Your Ref:
Our Ref: EP/137/11/
Please ask for:
Mrs A Gardner

11th January 2012

Willowhayne Estate Entrance Gates The Ridings, Tamarisk Way and Angmering Lane
East Preston

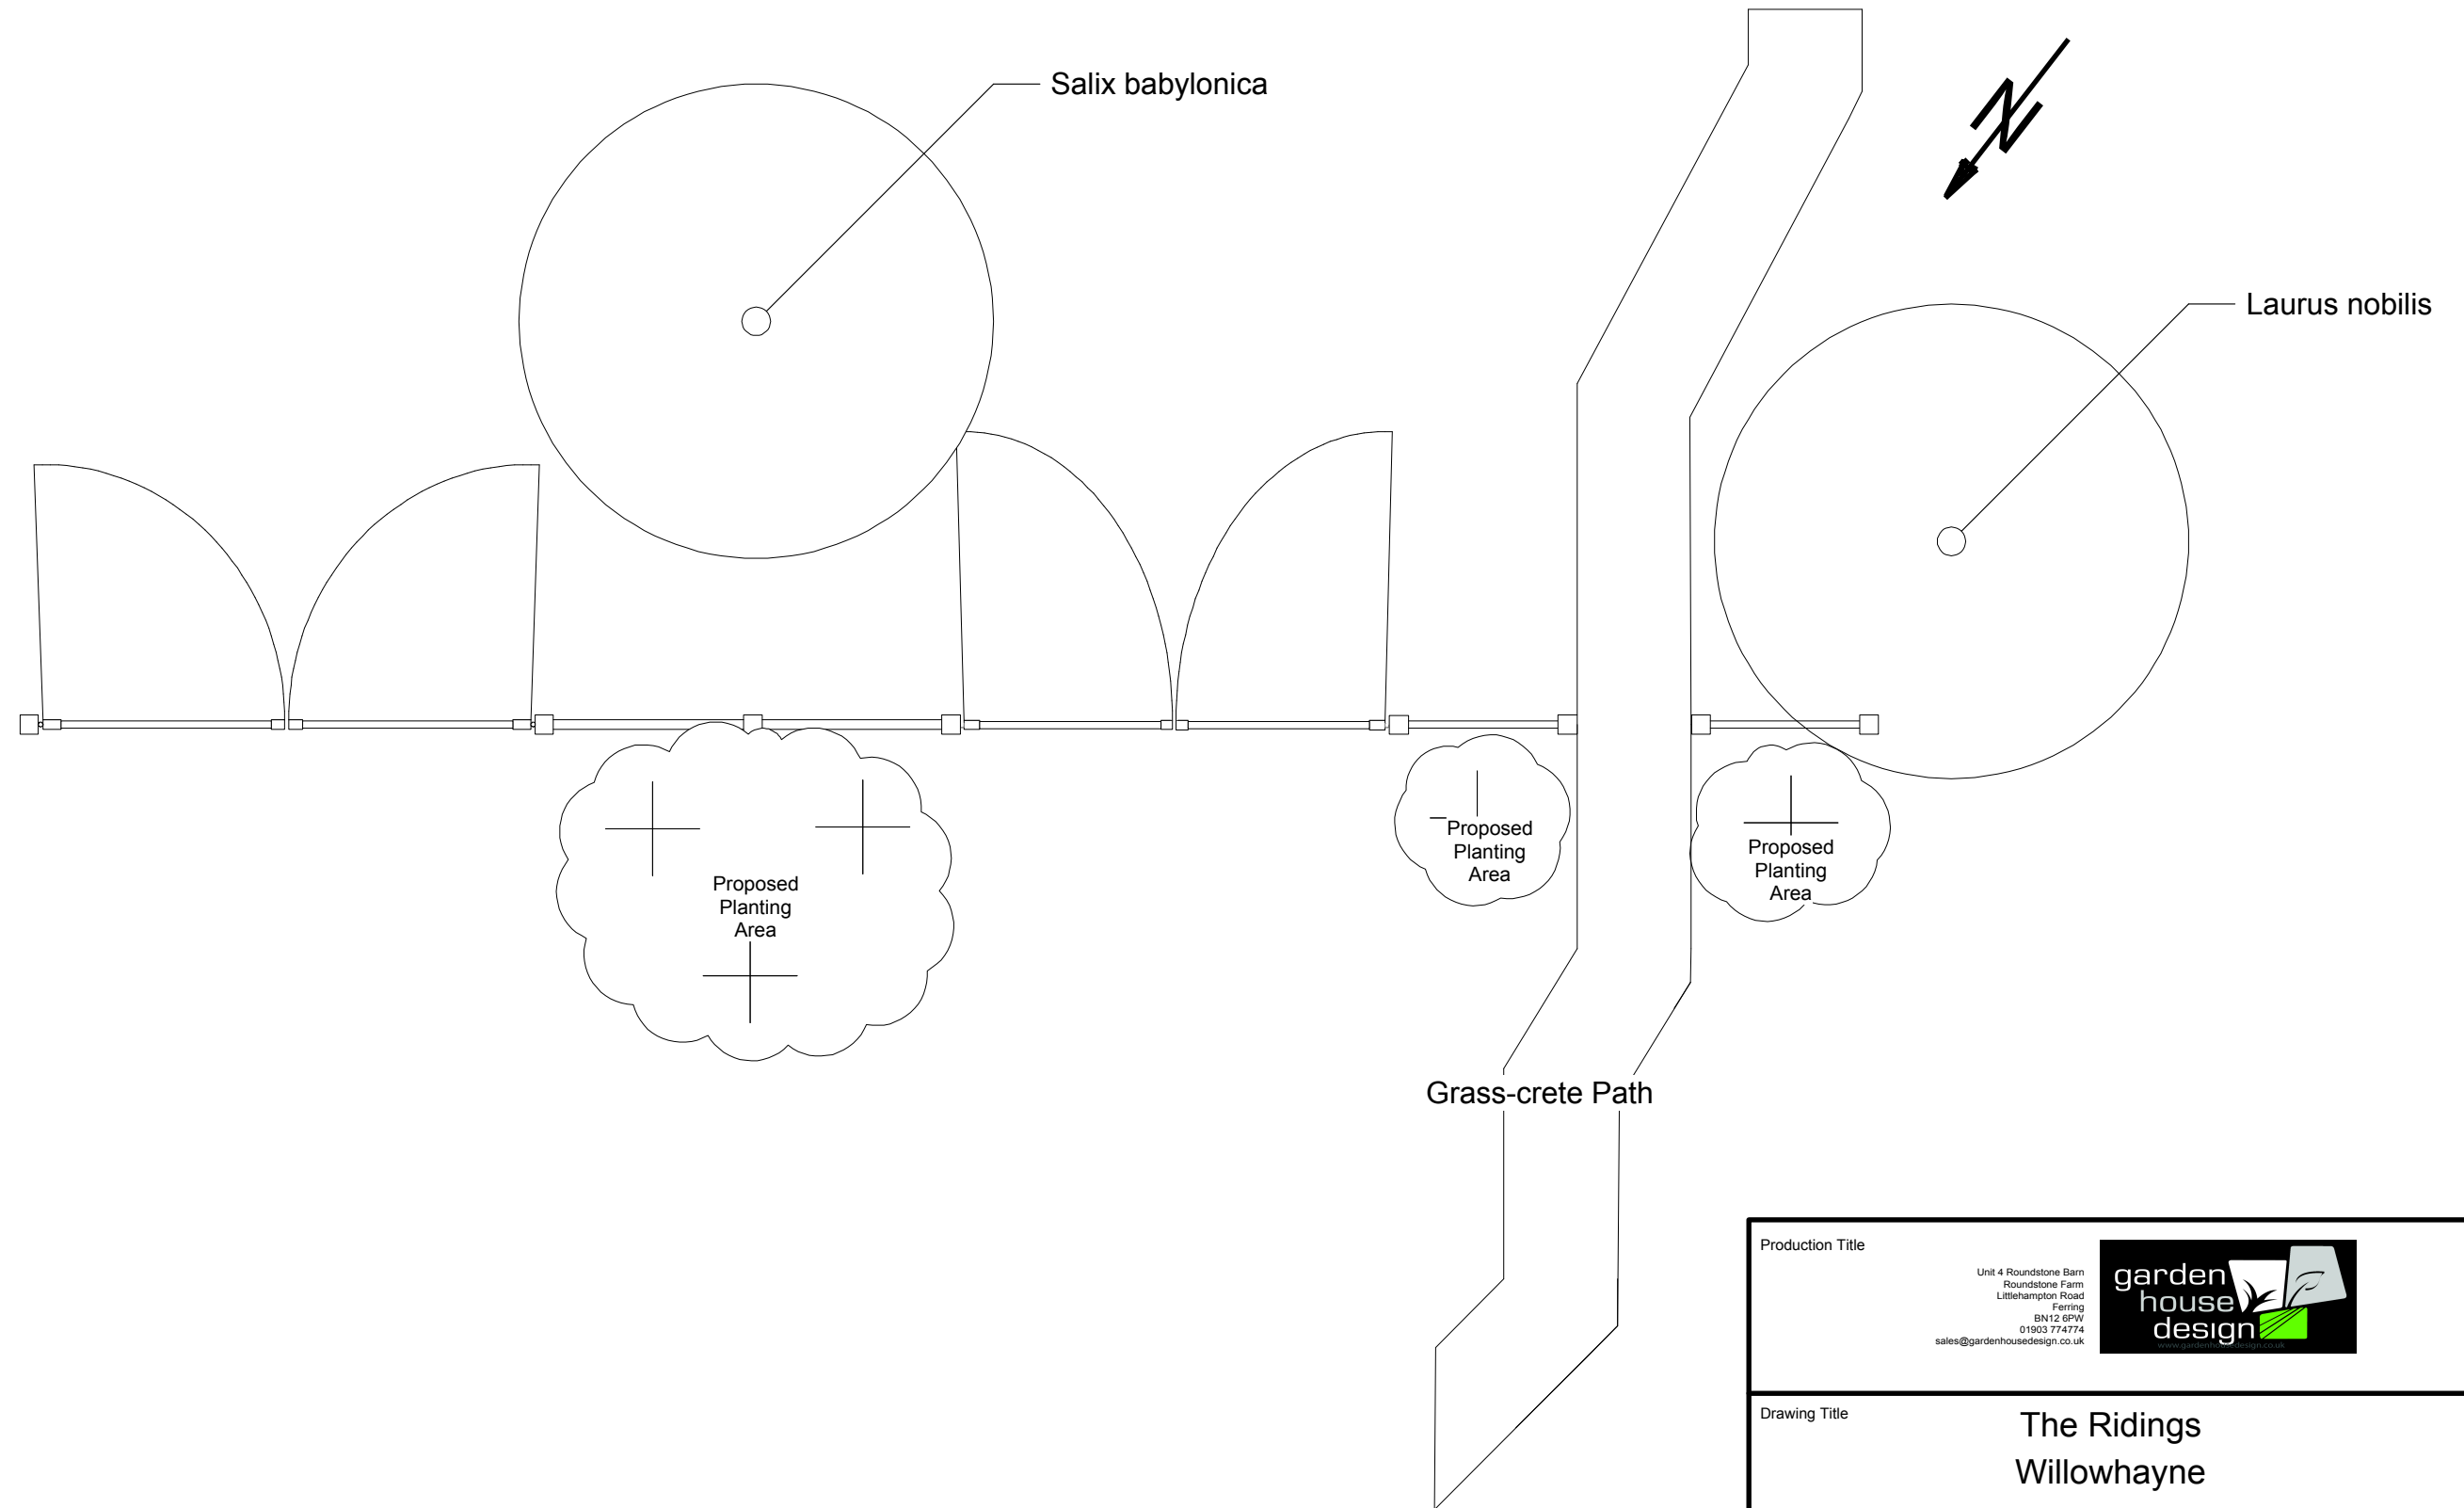
Firstly, could the Residents Association consider a three-bar design as this may appear even more open than the five-bar design?

Secondly, please could the Residents Association confirm that the pedestrian accesses are suitable for a range of mobility vehicles.
